CITY OF ALBUQUERQUE

December 27, 2024

**RE: Chavez Residence
7212 Osuna Rd. NE
Grading & Drainage Plan
Engineer's Stamp Date: 12/23/2024
Hydrology File: F19D040**

G1

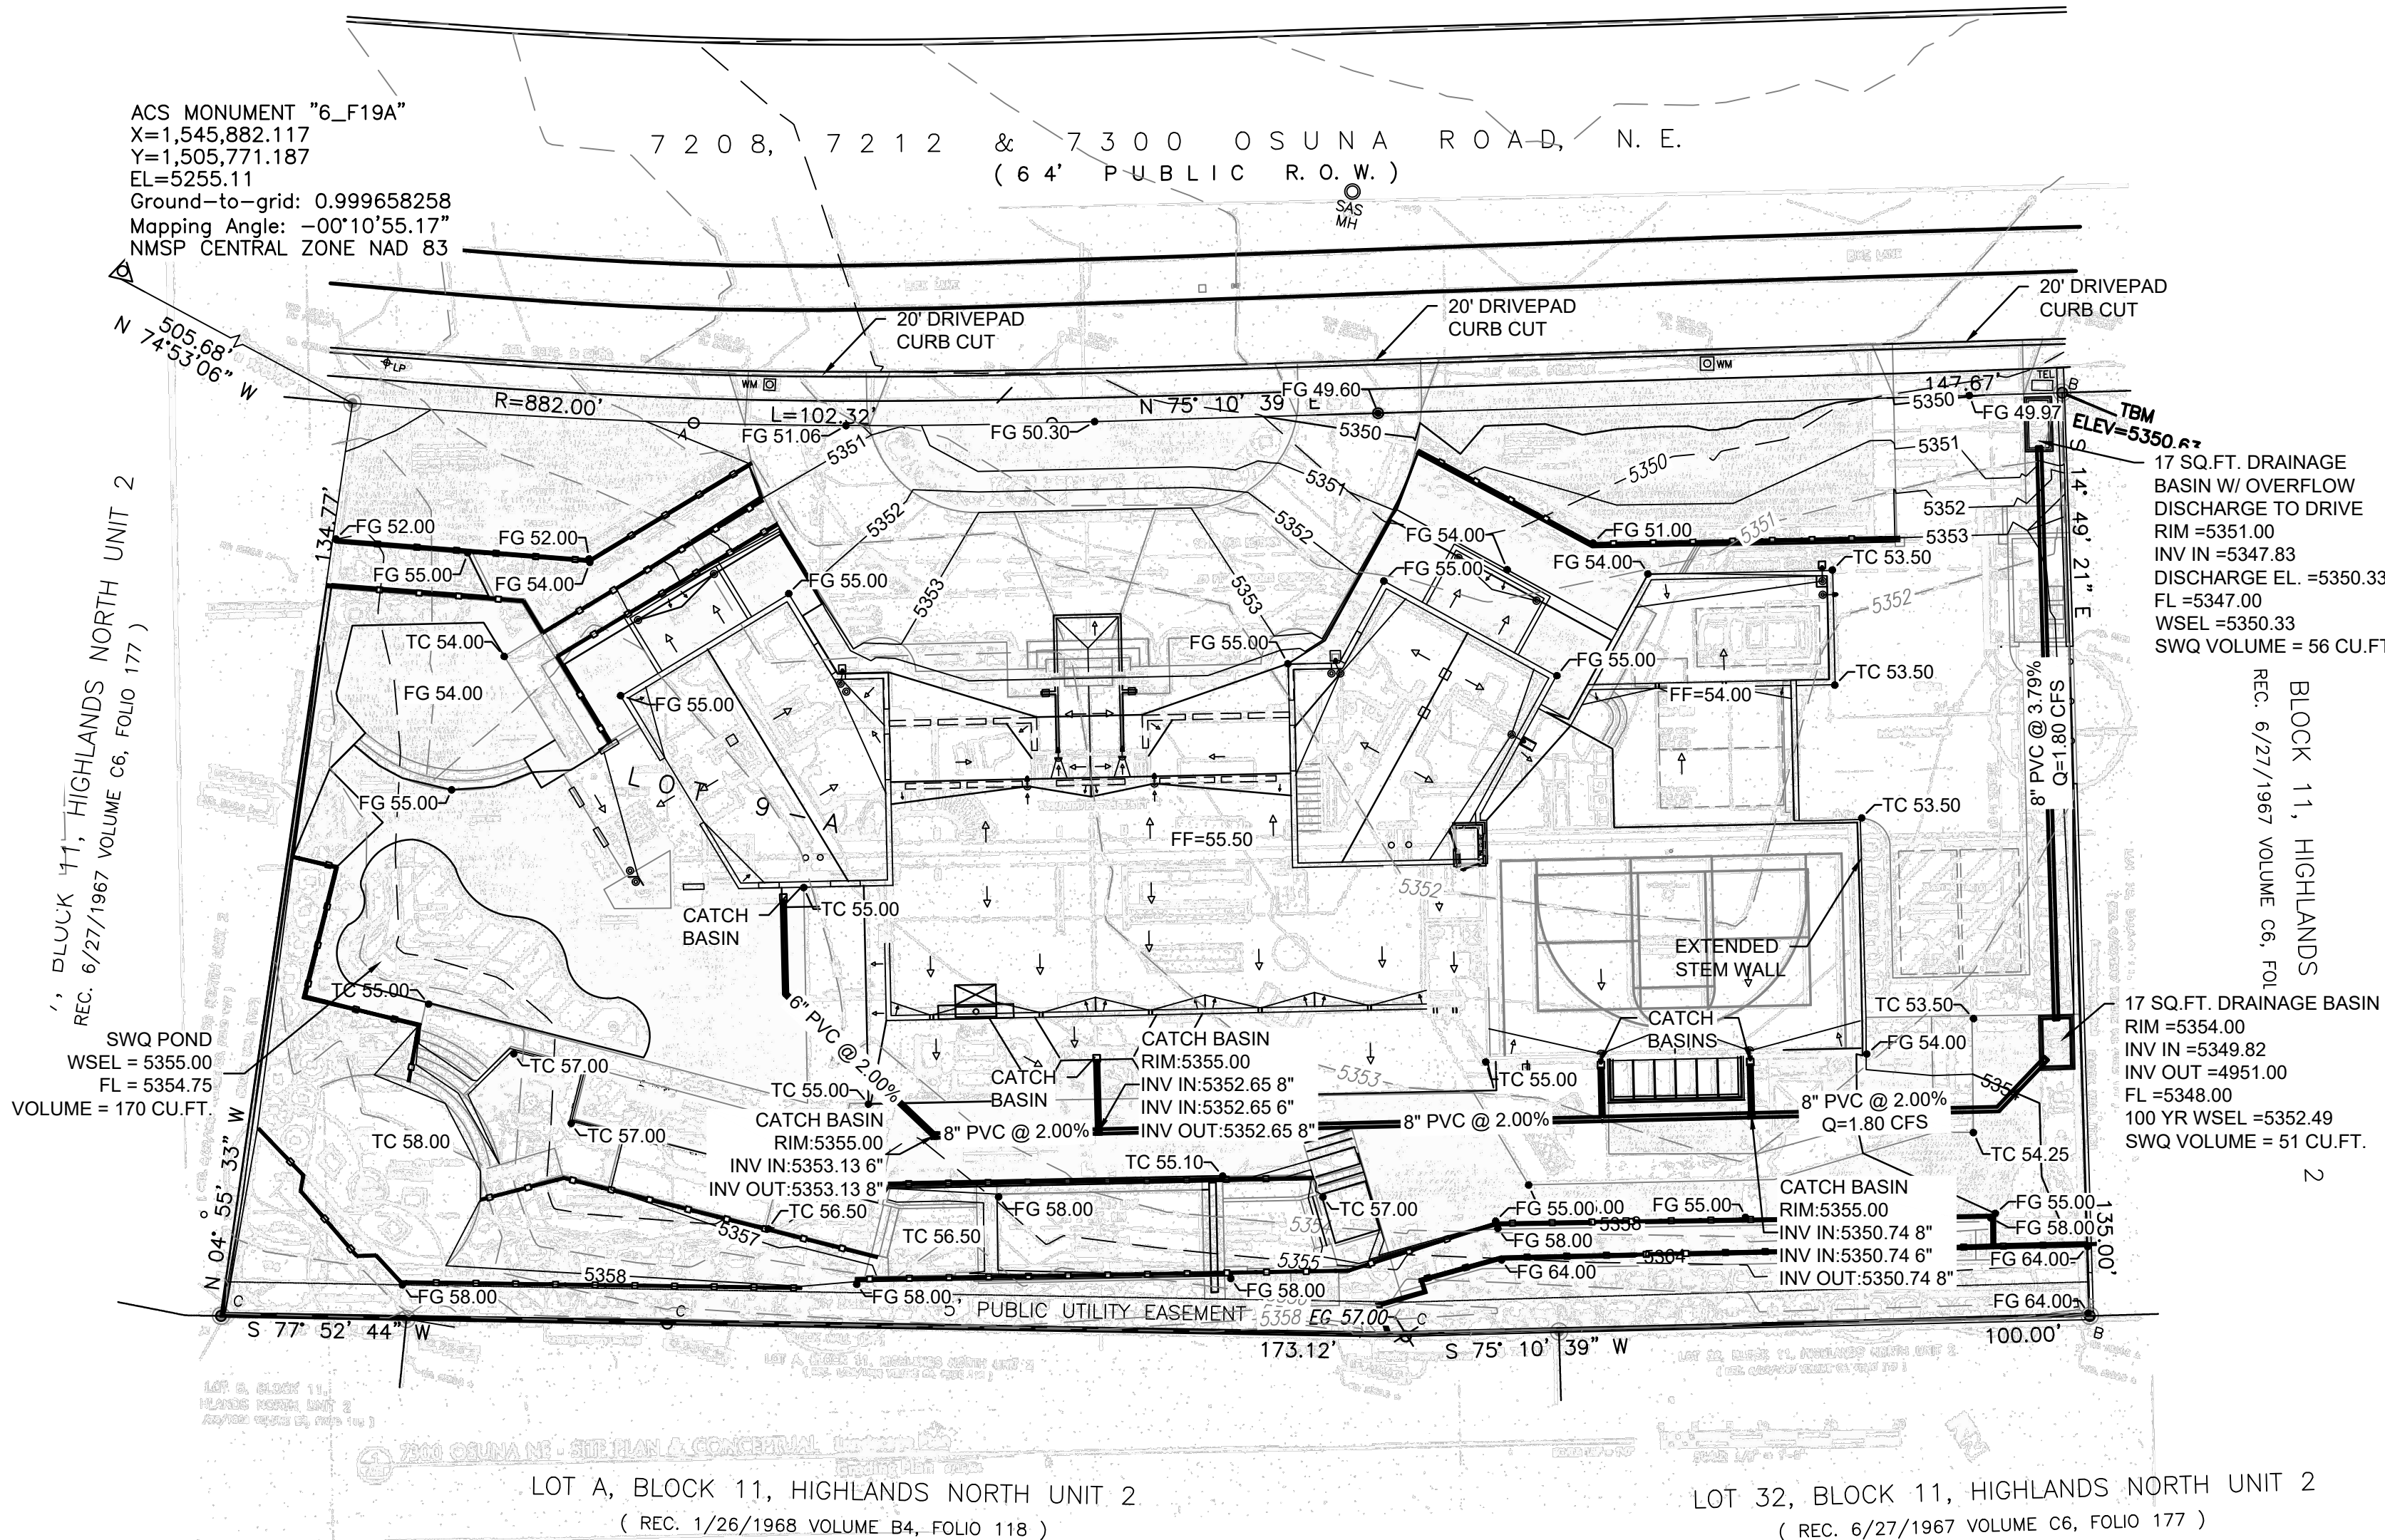
1. PRECIPITATION: Change to Zone 3 in the narrative.
2. Please number the ponds and include a label on each with the SWQV and elevation, the 100-year volume and elevation, the peak 100 year inflow and outflow, the spillway crest elevation, the spillway flow depth, and the dam top elevation.
3. Please provide the Benchmark information (location, description and elevation) for the survey contour information provided.
4. Please show all proposed drivepads on the plan.
